KIRKLEES METROPOLITAN COUNCIL INVESTMENT & REGENERATION SERVICE

DELEGATED DECISION TO DETERMINE PLANNING APPLICATIONS

Reference No:	2026/62/90188/W
Site Address:	28, Fairfields Road, Holmbridge, Holmfirth, HD9 2NP
Description:	Formation of patio to rear elevation and replacement windows and doors with associated alterations (Listed Building within a Conservation Area)
Recommending Officer:	Joshua Merriman

Officer Report – 2026/90188

DRAWING DESCRIPTION
EXISTING & PROPOSED FLOORS PLANS & ELEVATIONS

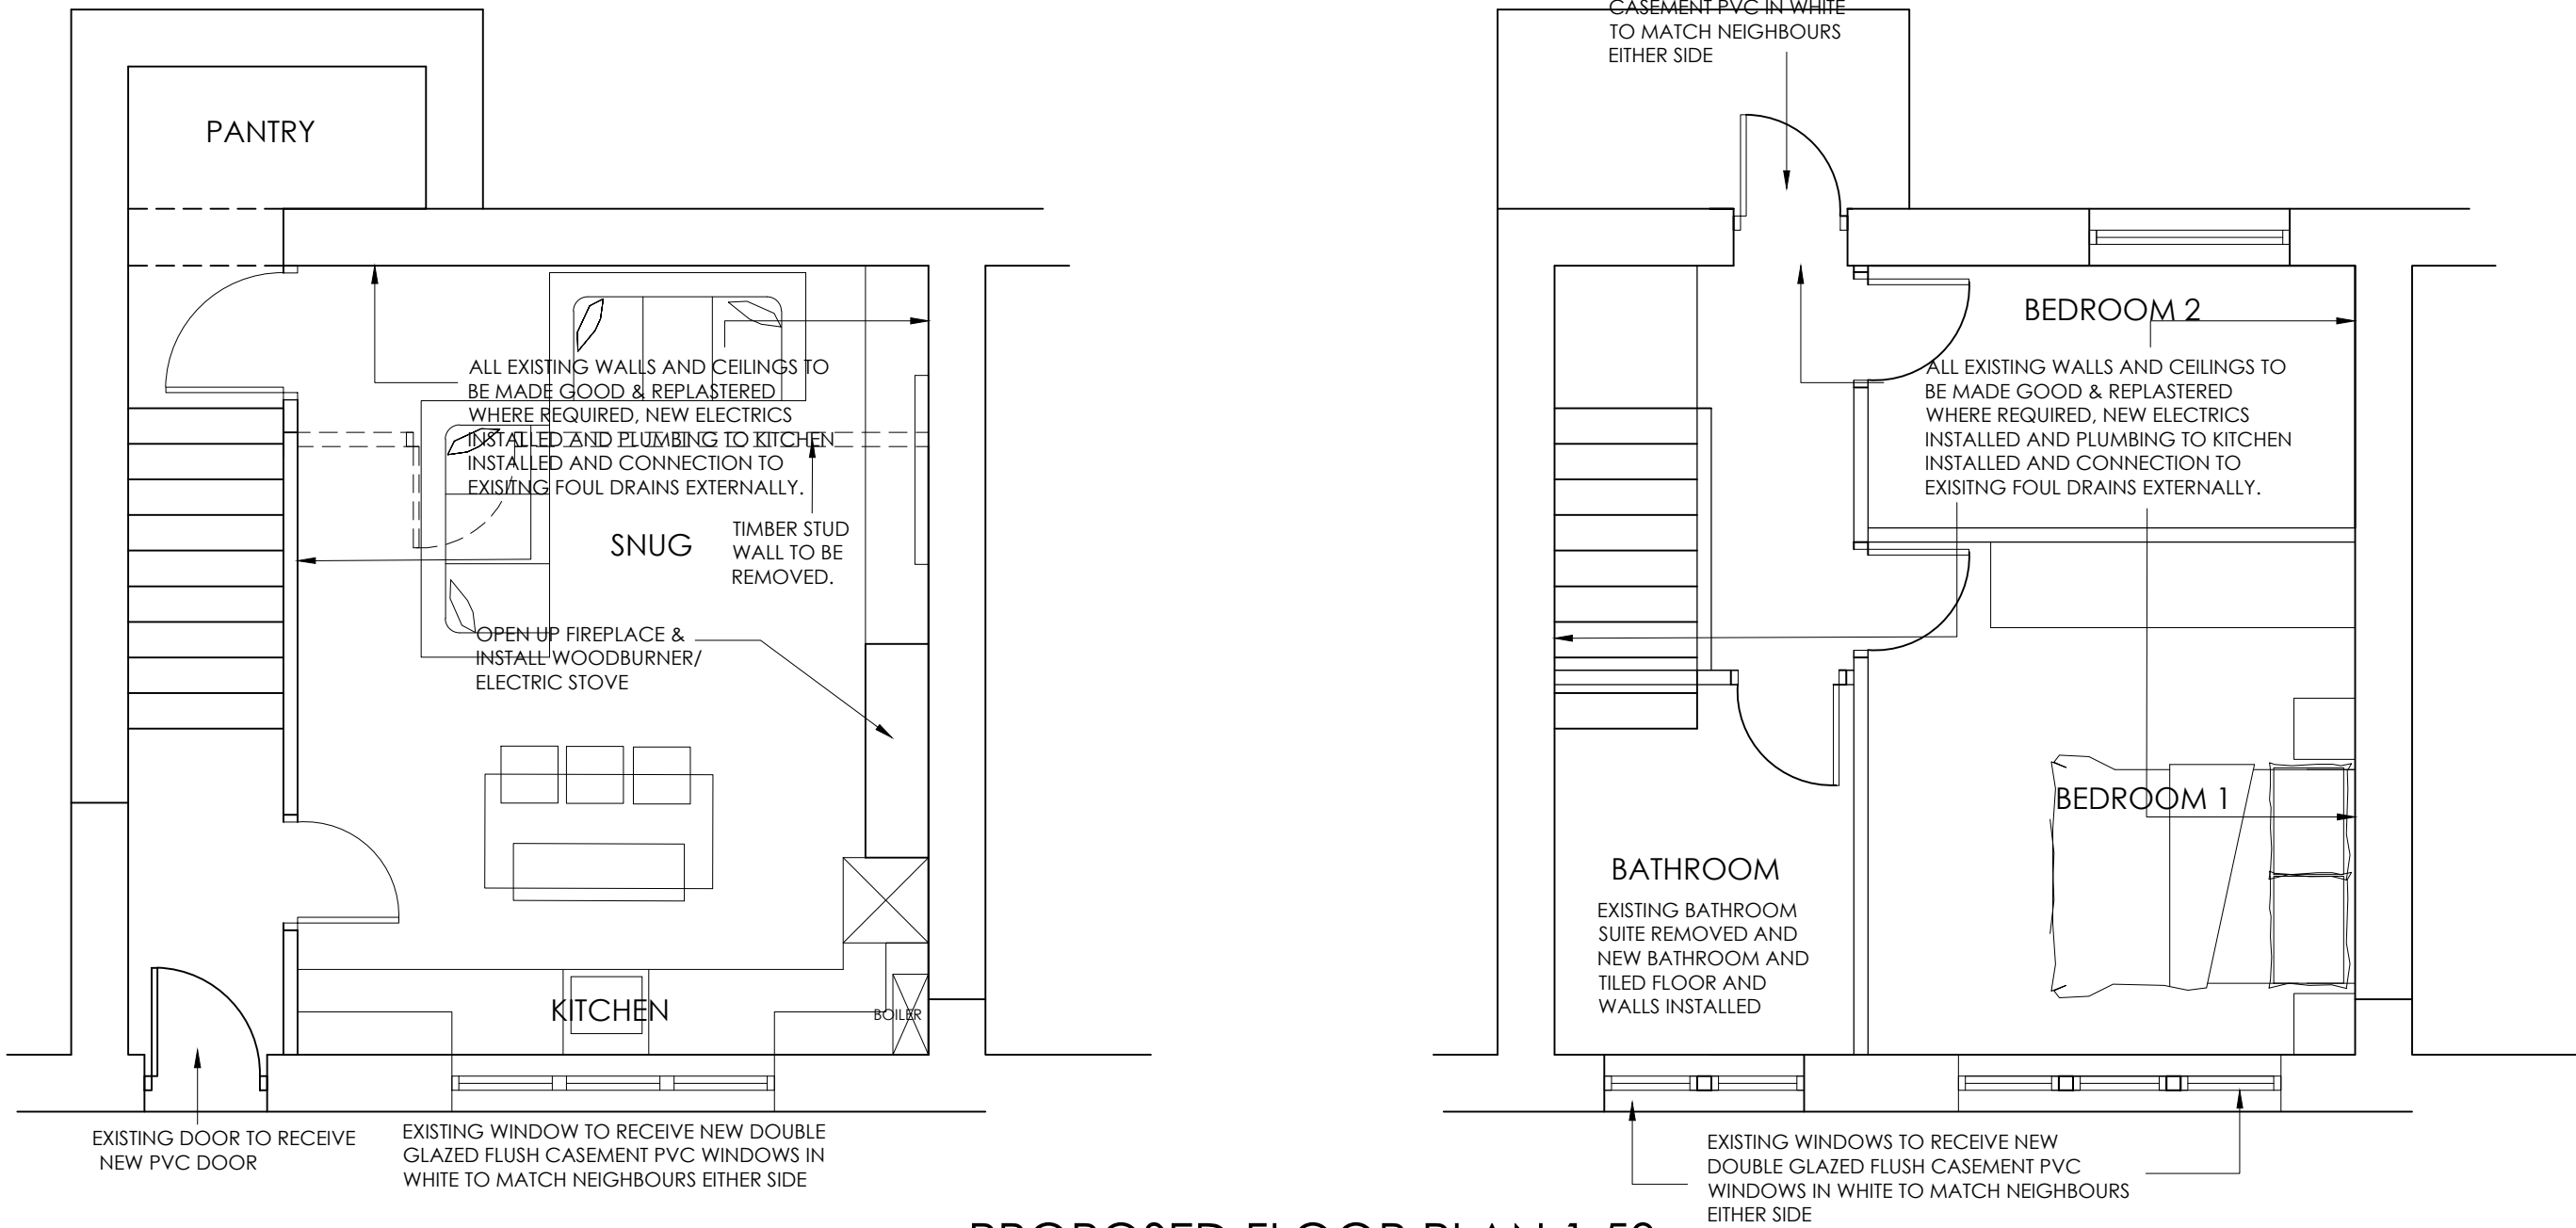
The case officer requested information to ensure the following details: the internal wall removed was not original; the request that the proposal be constructed with timber windows and a timber door to the front elevation rather than uPVC; the use of breathable plaster materials; recessing of the rear glazed patio door; the use of matching natural stone for the patio retaining wall with matching pointing, replacement rainwater goods to be timber/metal and black in colour; and any pointing to be lime mortar and flush or recessed.

KC Conservation & Design (Informal) – Conditions should be added to any permission to ensure the following; the internal wall removed was not original, the use of timber windows and a timber door to the front elevation rather than uPVC, the use of breathable plaster materials, recessing of the rear glazed patio door, the use of matching natural stone for the patio retaining wall with matching pointing, replacement rainwater goods to be timber/metal and black in colour, and any pointing to be lime mortar and flus or recessed.

Despite the rear patio door being glazed and not entirely timber, as the rear of the dwelling is well obscured by high hedges surrounding the garden space, it is considered that this will not be largely visible and thus will not significantly detract from the heritage value of the dwelling nor the wider conservation area. This is also the consideration for the proposed rear patio area.

2. Notwithstanding the details provided, all new windows shall be constructed in timber. No works to install new windows shall take place until joinery details at 1:5 and elevations at 1:20 have been submitted to and approved in writing by the Local Planning Authority. Windows shall be fixed light or side hung casements with a painted finish, with mouldings and timber sections simple in design and profile with chamfered glazing beads. All double-glazed units shall be slim in section, with 4mm glass and an 8mm gap with black spacer bars. Opening casements shall be set flush with the frames with butt hinges and traditional window stays (friction hinges and visible trickle vents shall not be permitted) and all new window frames shall be set back in the reveal by 100-125mm and not fitted flush with the external wall. The works shall then be carried out in complete accordance with the approved details.

3. Notwithstanding the details provided, new external doors to the front elevation shall be constructed in timber with a painted finish, with mouldings and timber sections simple in design and profile with chamfered glazing beads. No works to install new doors shall take place until joinery details at 1:5 and elevations at 1:20 have been submitted to and approved in writing by the Local Planning Authority. All double-glazed units shall be slim in section, with a 4mm-20mm-4mm window configuration with black spacer bars. All new external door frames shall be set back in the reveal by 100-150mm and shall not be fitted flush with the external wall. The works shall then be carried out in complete accordance with the approved details.

4. The heads, cills and jambs for the new opening shall be of natural stone and shall replicate the heads, cills, and jambs of the existing windows and doors in terms of stone type, material, colour, size, tooling and section.

5. Any pointing should be carried out using a lime-based mortar. Stonework should be repointed or bedded in an appropriate lime mortar mix (that is, one weaker or softer than the adjacent masonry) and ideally a 1:3 mix (lime: sand). No power tools shall be used to remove the existing mortar and the mortar shall be flush pointed. Weatherstruck, strap or ribbon pointing is not permitted.

6. All rainwater goods shall be either timber, cast iron or cast aluminium.
